**EXHIBITION OF EIS (SSD10325)  
THE KINCOPPAL SCHOOL AT ROSE BAY**

Thank you for referring the abovementioned development' Environmental Impact Statement (EIS) to Transport for NSW (TfNSW) for comment. TfNSW has reviewed the EIS and the associated Transport Impact Assessment (TIA) and provides advisory comments in **TAB A**.

### Vehicle Swept Paths

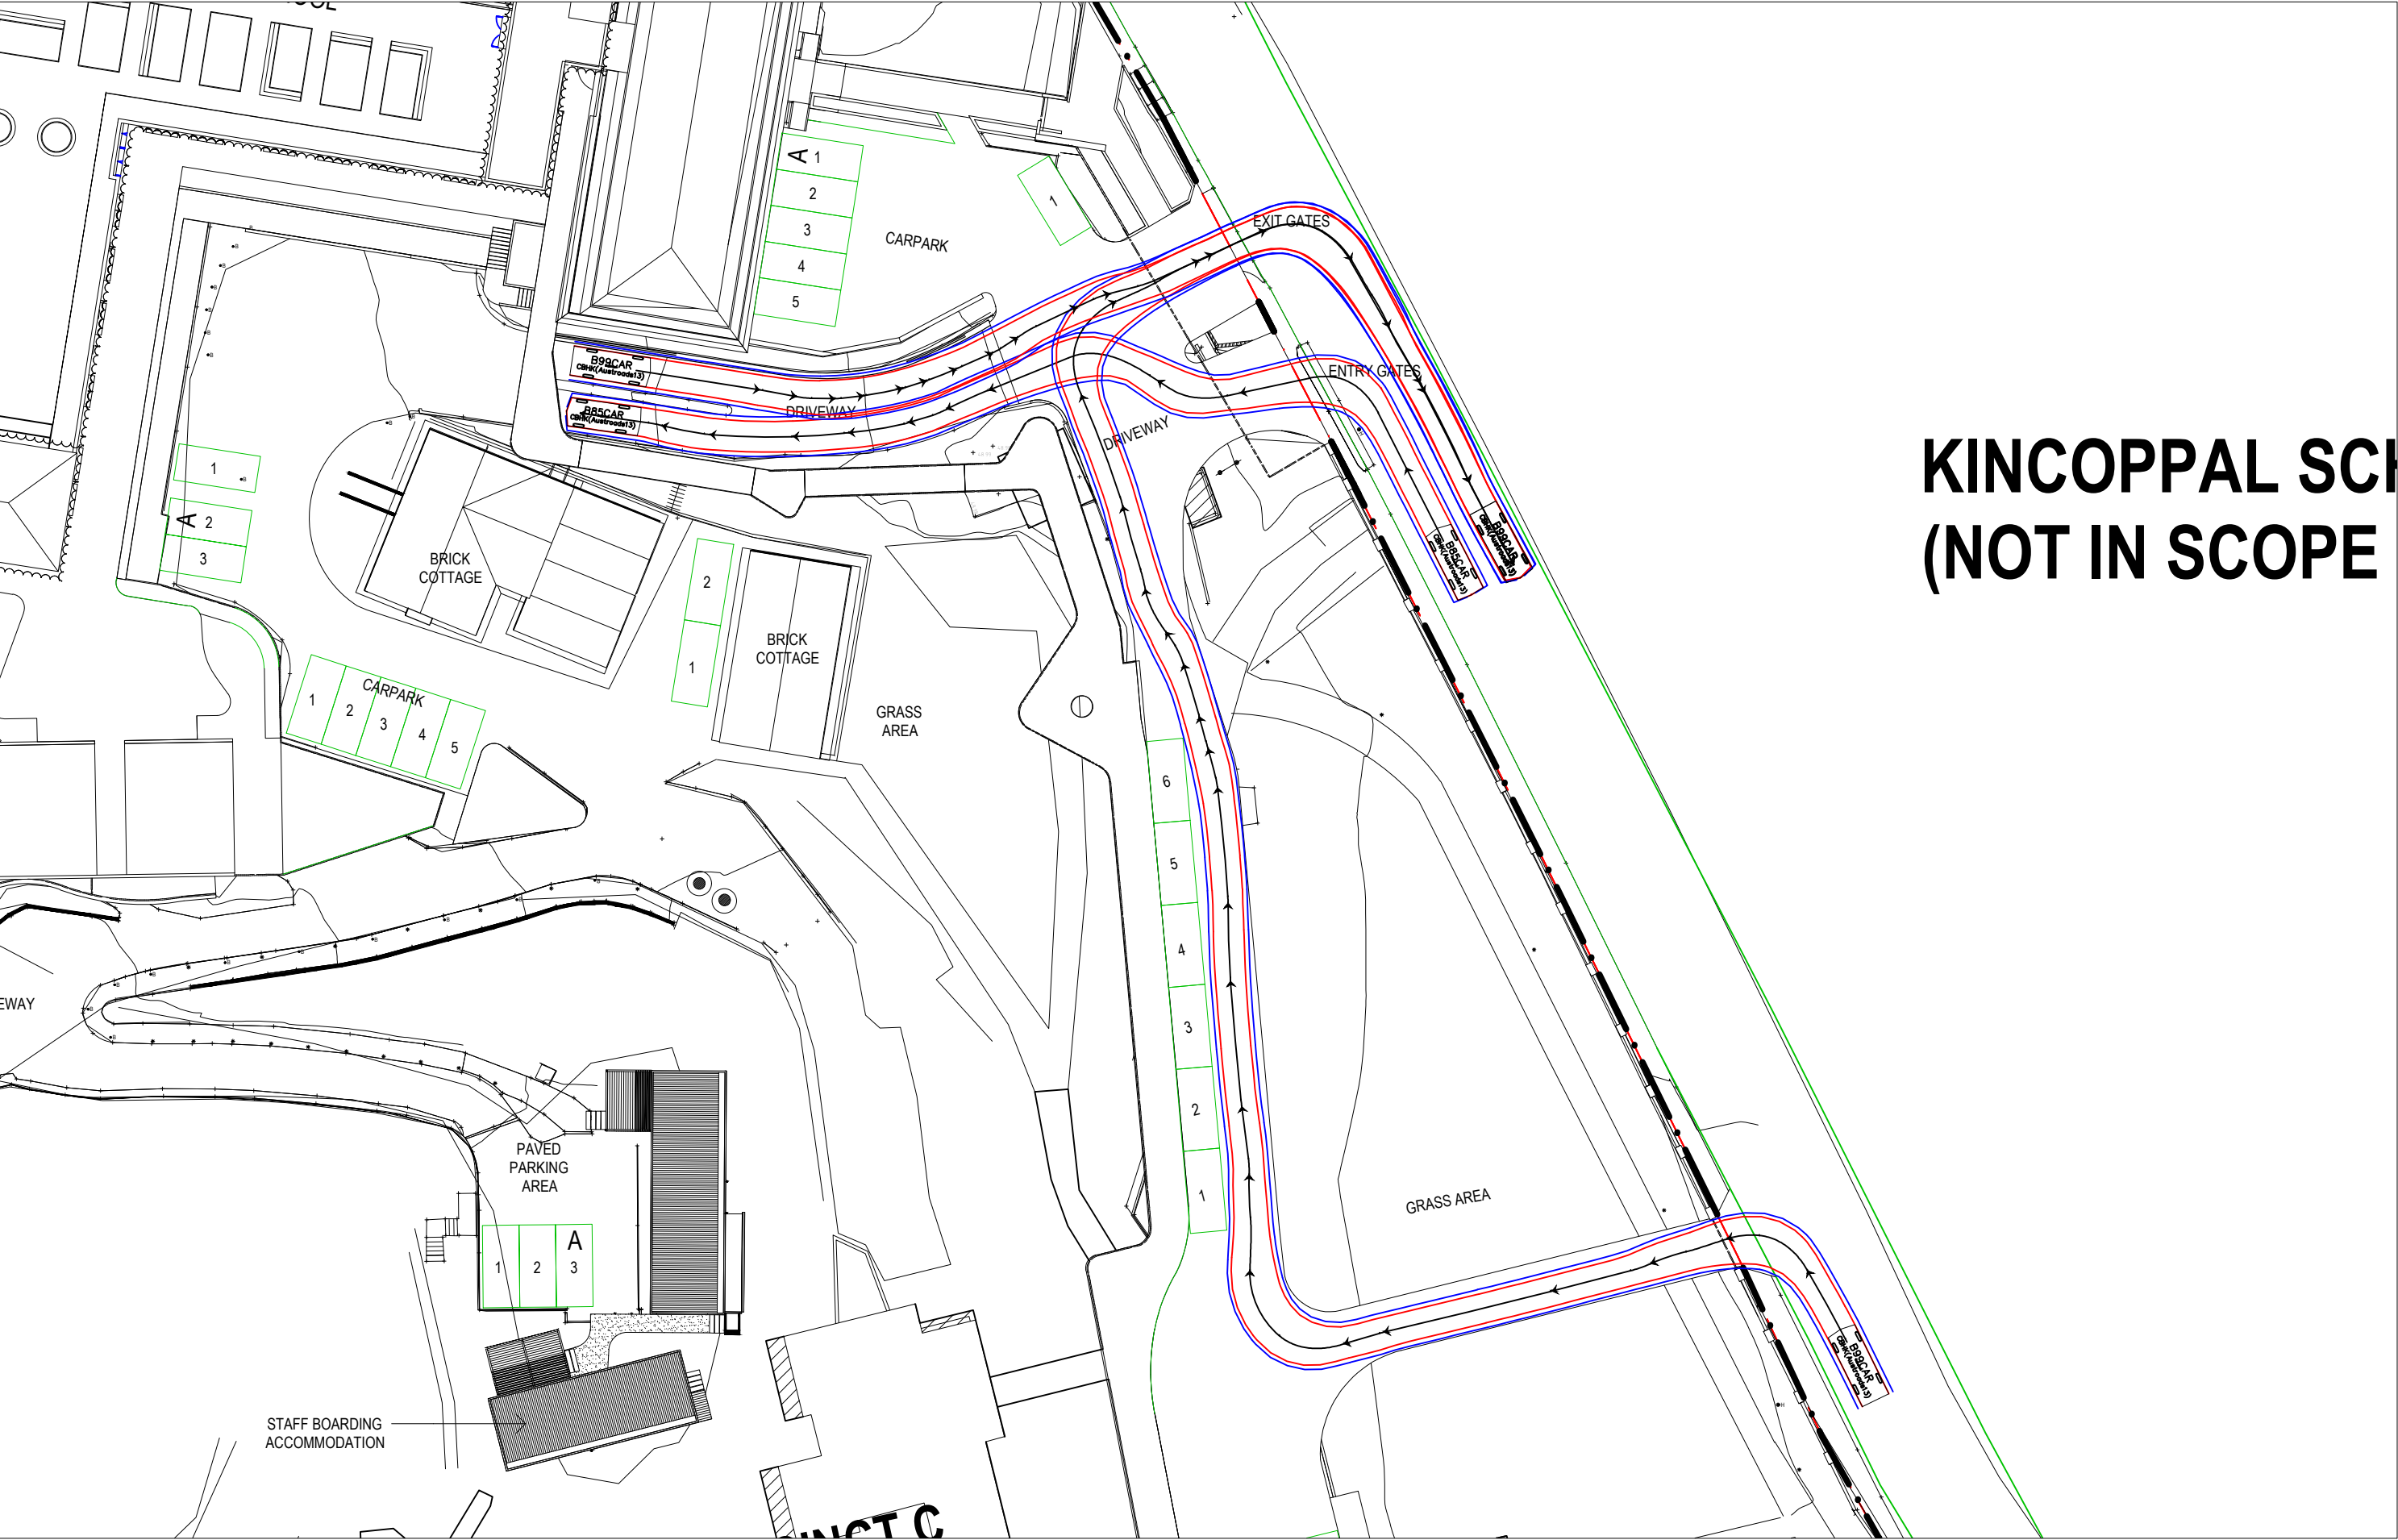
Swept paths for the proposed basement staff parking in the Senior School do not show vehicles being able to enter and exit car spaces. Particular concern is raised for car spaces 7, 16 and 23.

Swept path modelling should demonstrate that all car spaces able to be accessed safely and efficiently in accordance with Australian Standard AS/NZS 2890.1.2004
